Our Ref: EN010147

Application by Photovolt Development Partners (PVDP) on behalf of SolarFive Ltd for an Order Granting Development Consent for the Botley West Solar Farm

Advice following issue of decision to accept the application for examination

Photovoltaic Development Partners GmbH
 Kurfürstendamm 52
 10707 Berlin, Germany

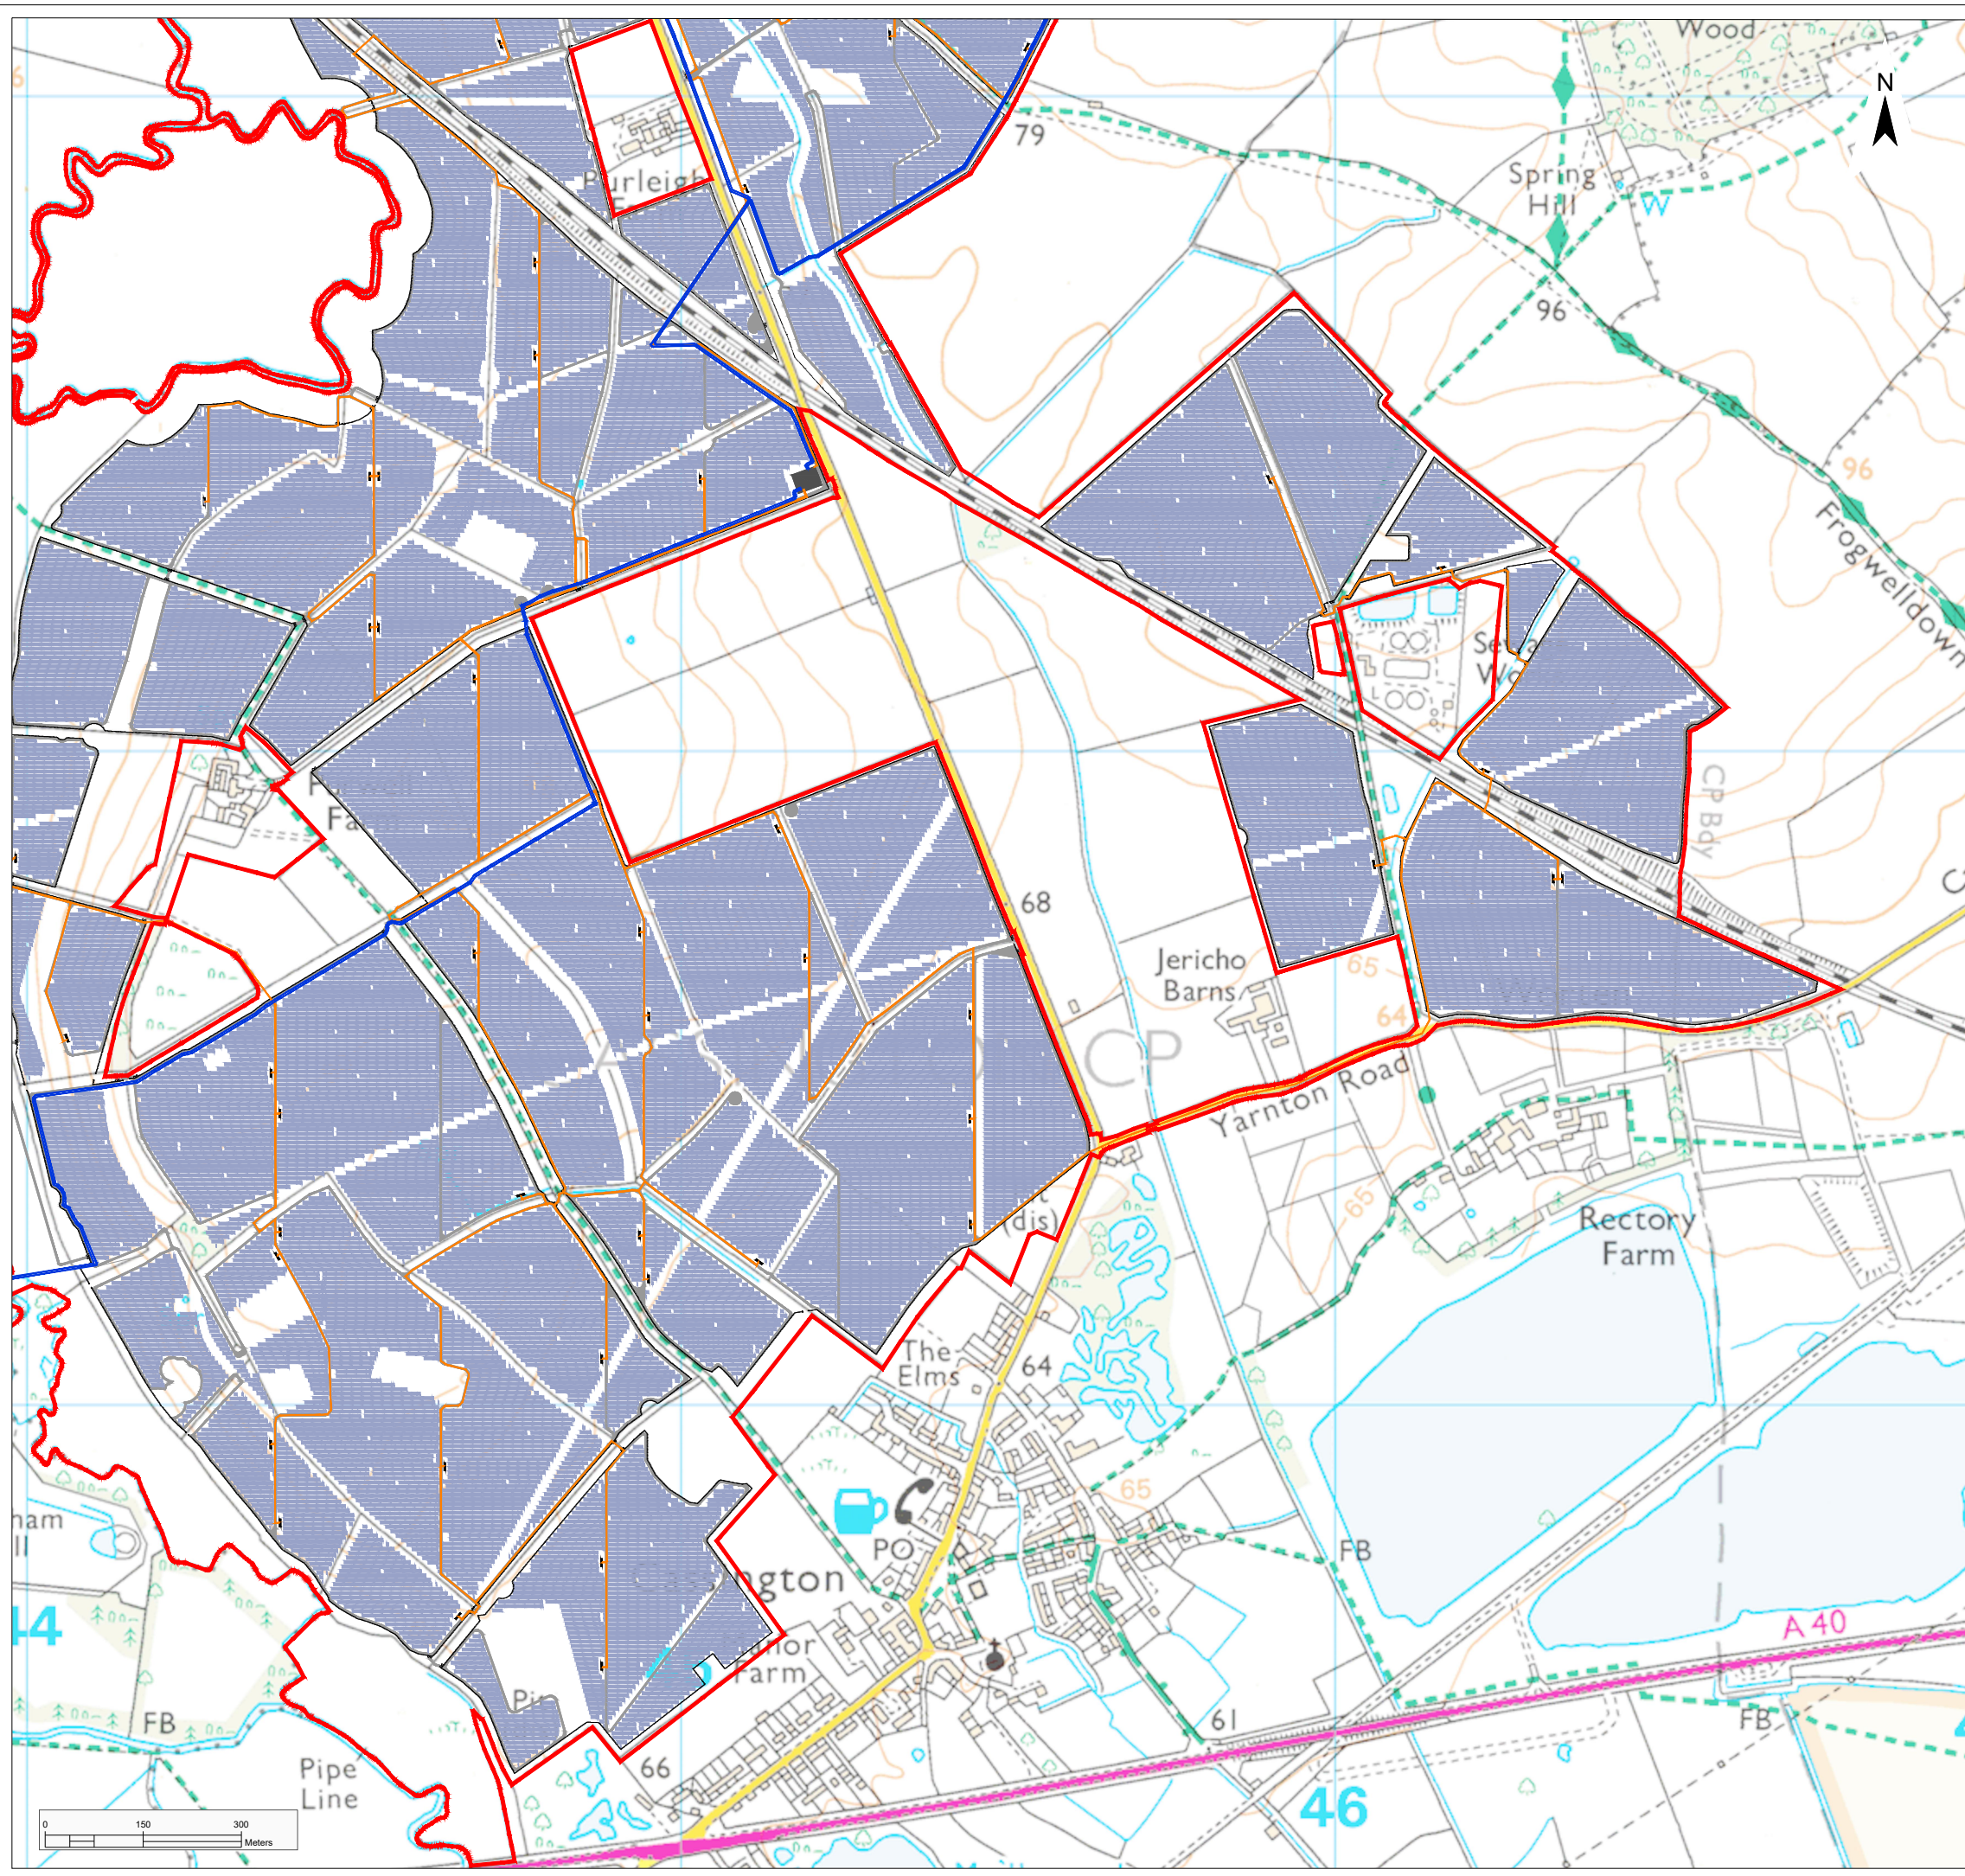
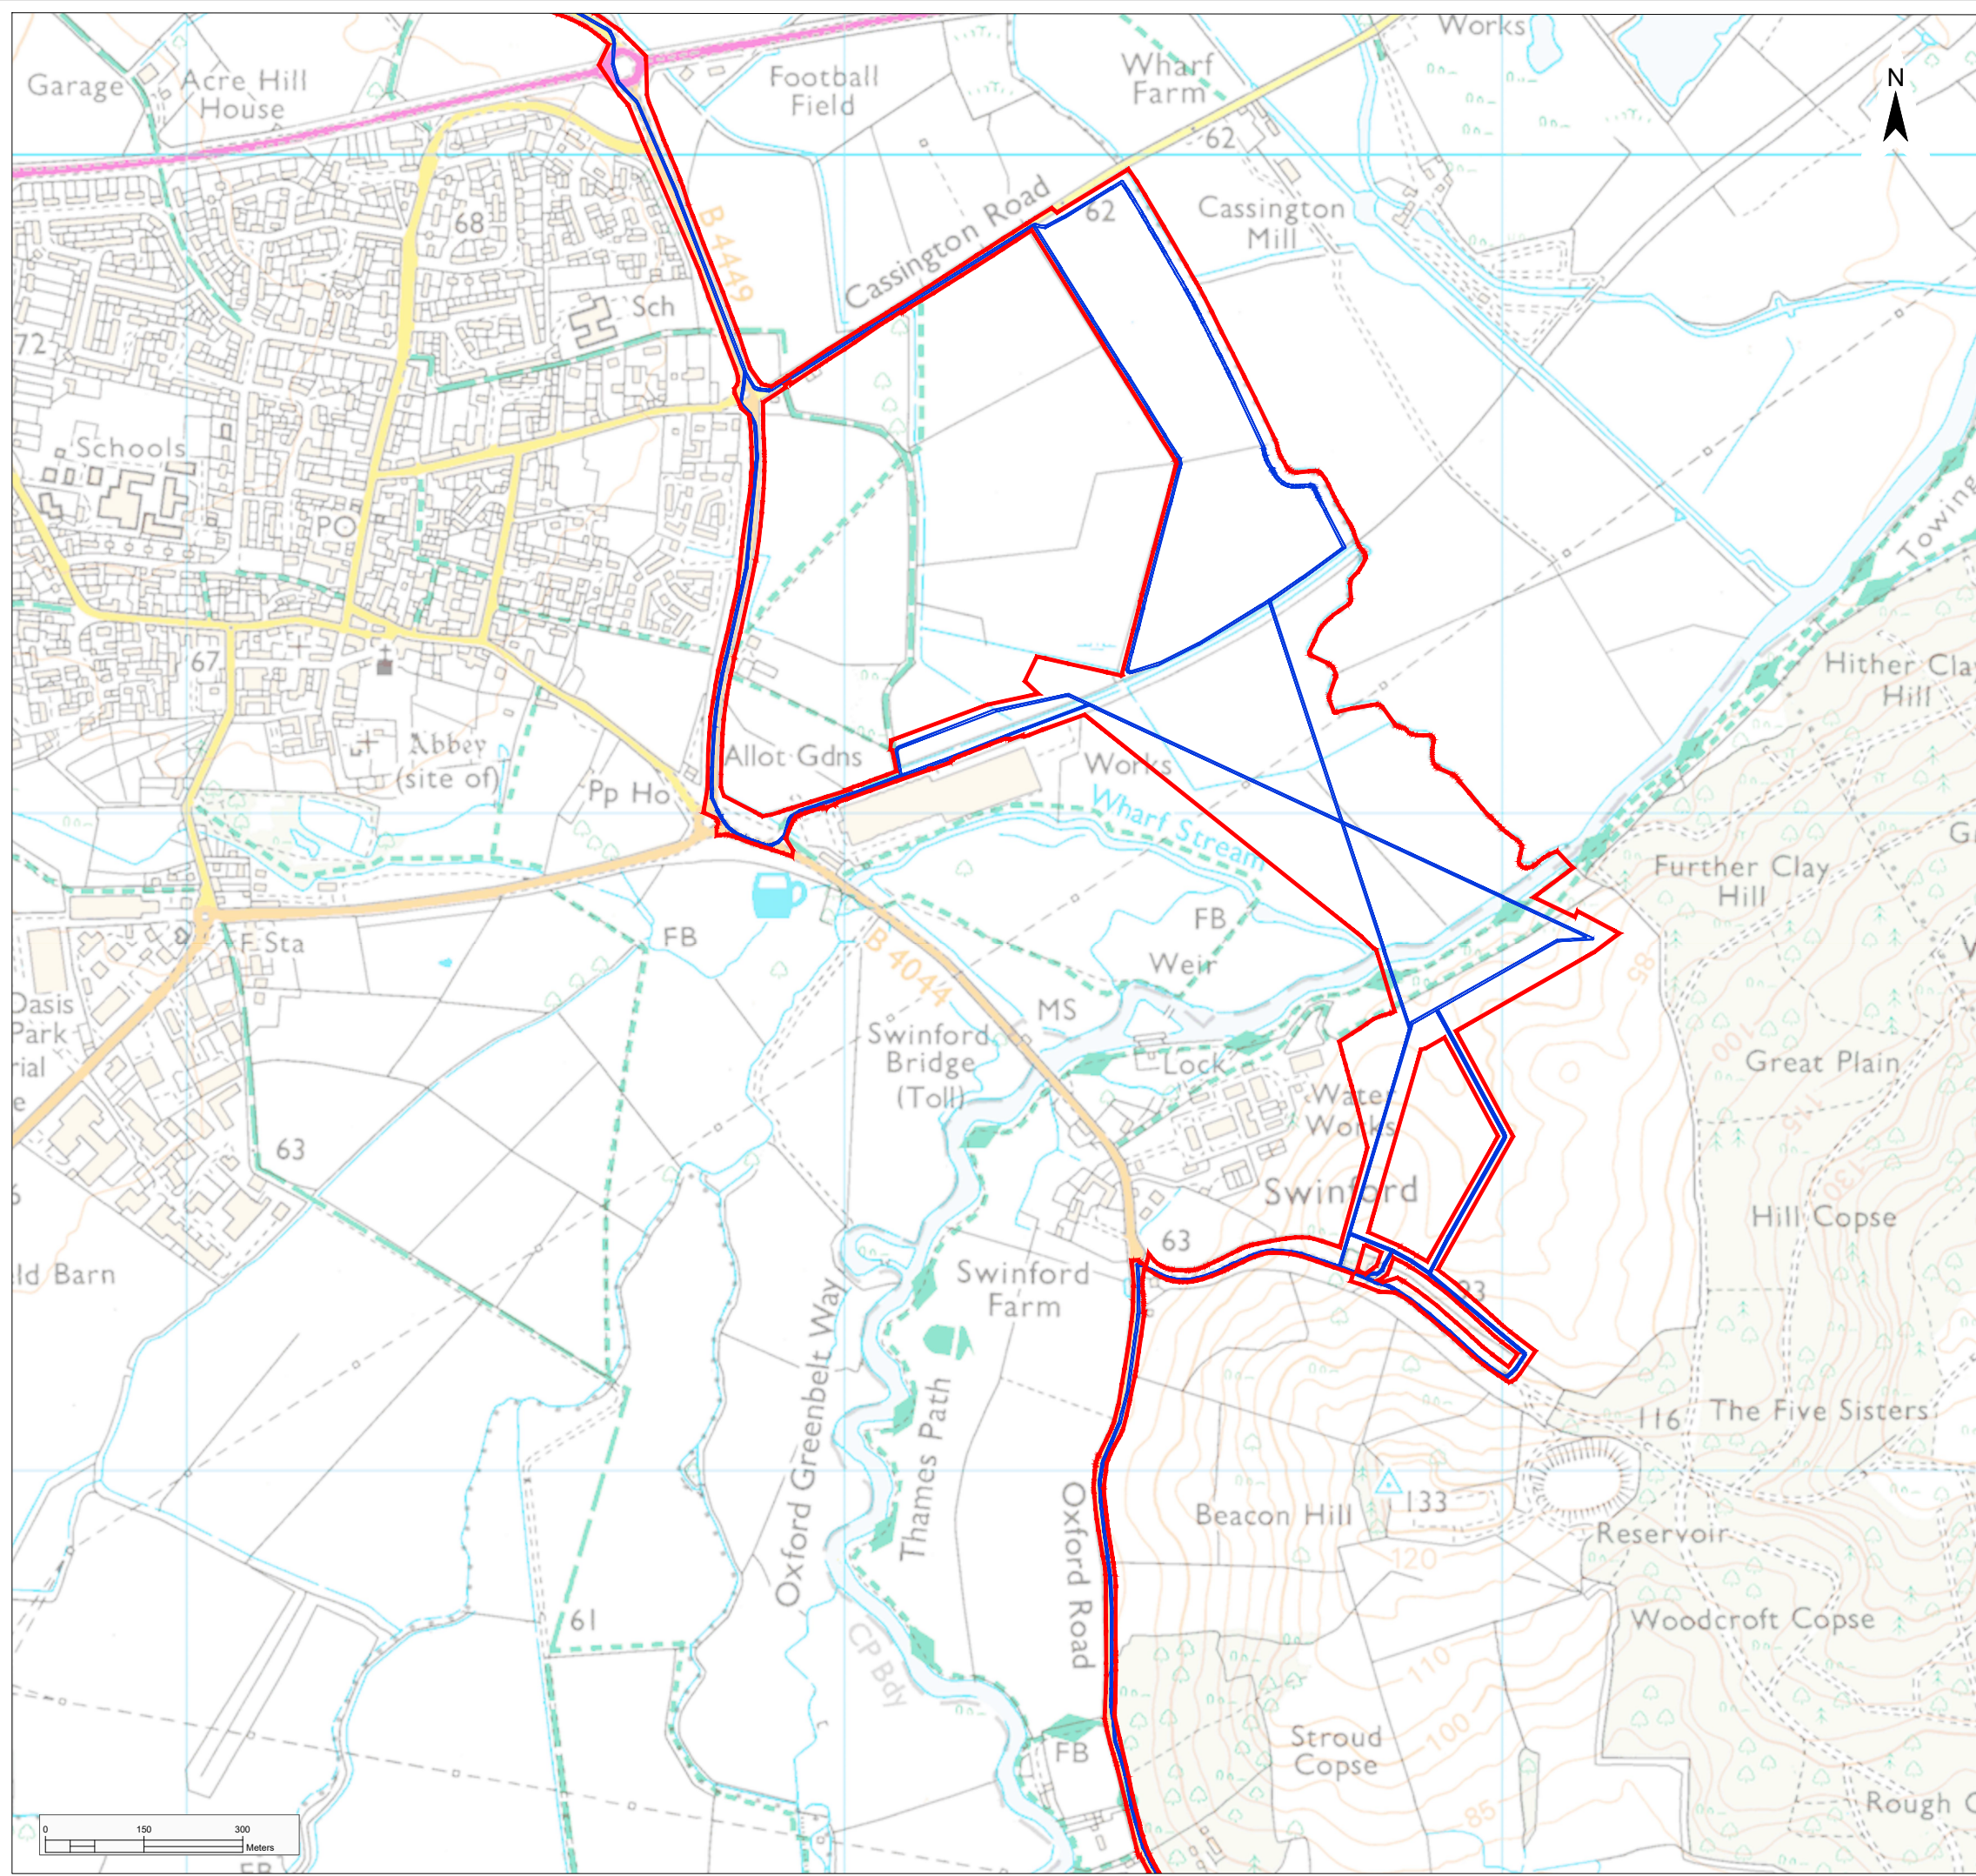
Operational Development Areas Plans (Doc 7.3.2), Landscape, Ecology & Amenities Layer Plan (Doc 7.3.3) and Temporary Facilities Plans (Doc 7.3.4)

The Inspectorate draws the attention of the applicant to APFP Regulation 5 (4A) in relation to these plan documents. The applicant may wish to amend these plans to ensure that the scale being used follows this regulation. For the benefit of the understanding of all parties to a future examination it may be desirable if it was more clearly presented on the plans which areas are within the Order Limits and how the sheet in question fits in the context of the wider site.
